Application reference number	2025/0230
-------------------------------------	-----------

Proposal Description:	Demolition of existing single garage together with single storey brick outbuilding and construction of new single storey retail unit
Location:	107 Houghton Road, Thurnscoe, Barnsley, S63 0NG

Recommendation: **REFUSE Planning Permission**

Drawing: GROUND FLOOR PLAN AS PROPOSED

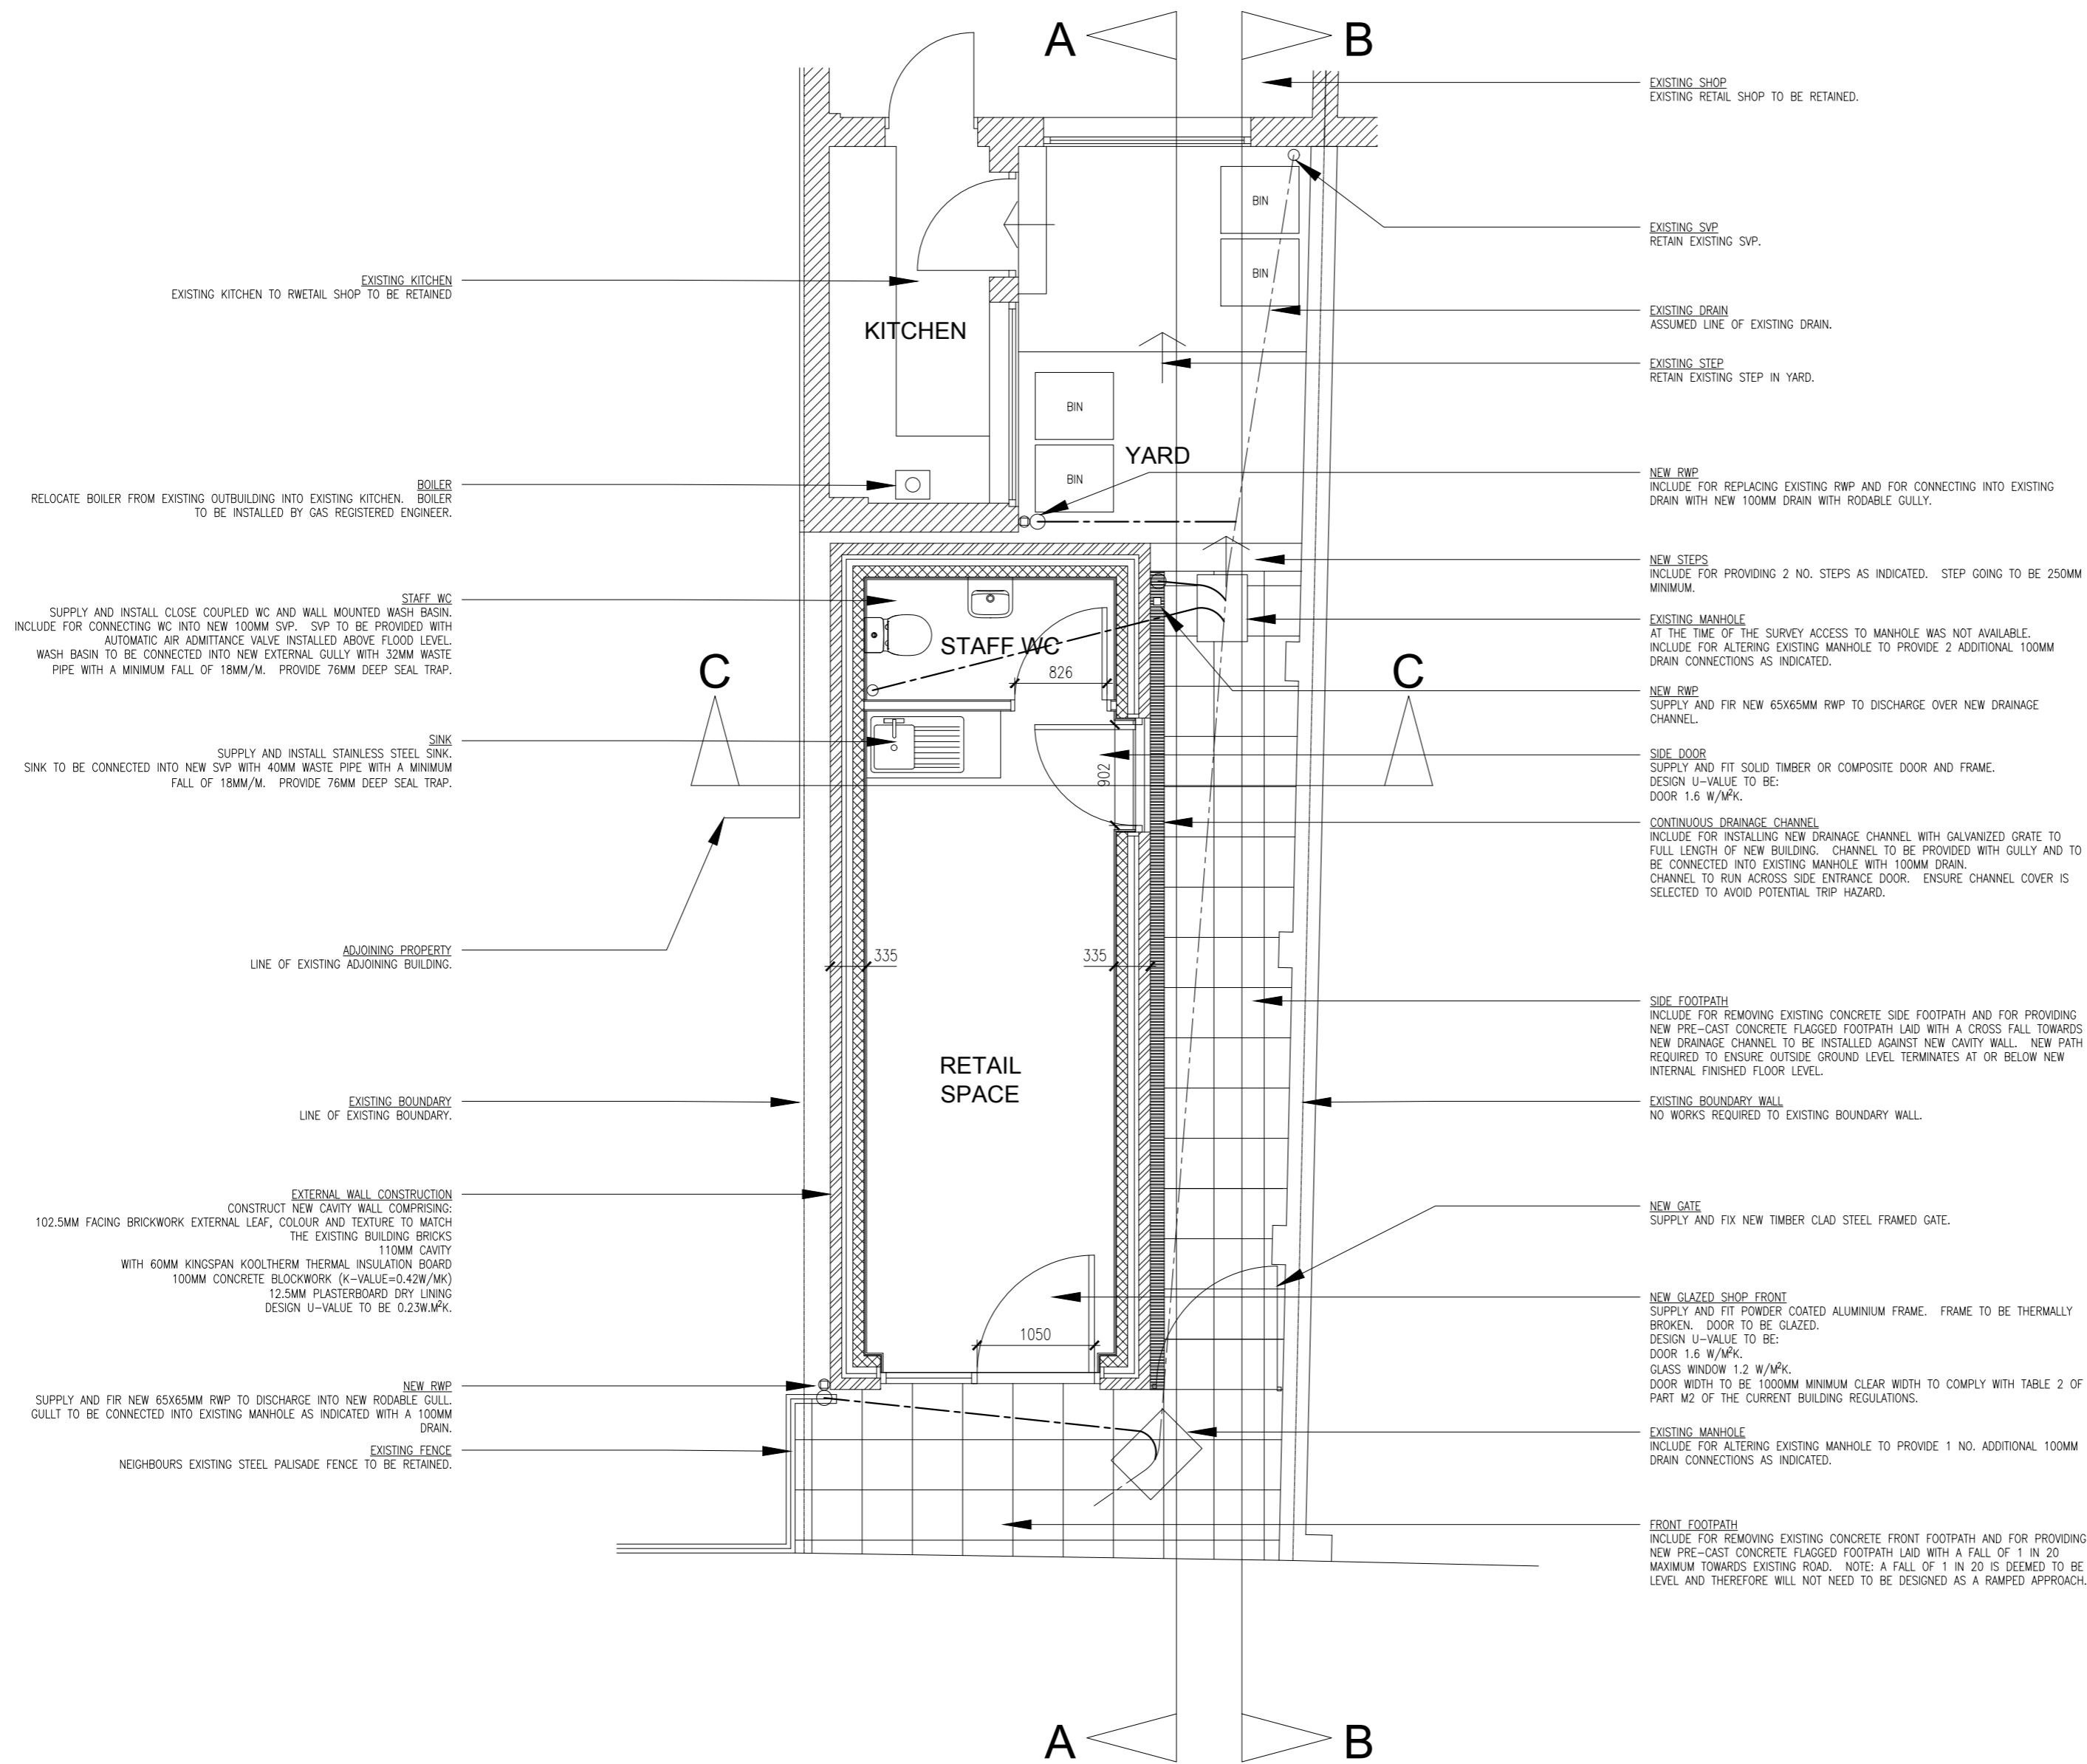
Advice from Highways Development Control expressed concern at the layout and location of the proposal for reasons including the apparent stepped route for bins to be brought to a suitable collection point and the lack of details about where bins will be presented on collection day; the lack of off street parking for either customers or staff and the loss of a garage which could provide parking provision for the existing site; and the lack of safe pedestrian route to the site given the lack of footway on the service road; and the lack of cycle storage.

The Council's Parking SPD indicates that for a use of this scale, at minimum of one parking space and two cycle parking spaces would be expected to be delivered. While it may be possible to overcome the concerns over bin storage and presentation, there appears to be no means for the concerns relating to the lack of off street parking provision and lack of safe pedestrian route to the site to be resolved. The proposal will be likely to result in additional vehicles driving and parking on a service road that is of insufficient width to accommodate such demand. It will also be likely to result in conflict between pedestrians seeking to access the site and vehicles using the service road given the lack of a safe pedestrian route to the proposed shop. The harm to pedestrian safety and lack of parking provision is in conflict with Local Plan policies T3 New Development and Sustainable Travel and T4 New Development and Transport Safety and this harm attracts significant weight against the proposal.
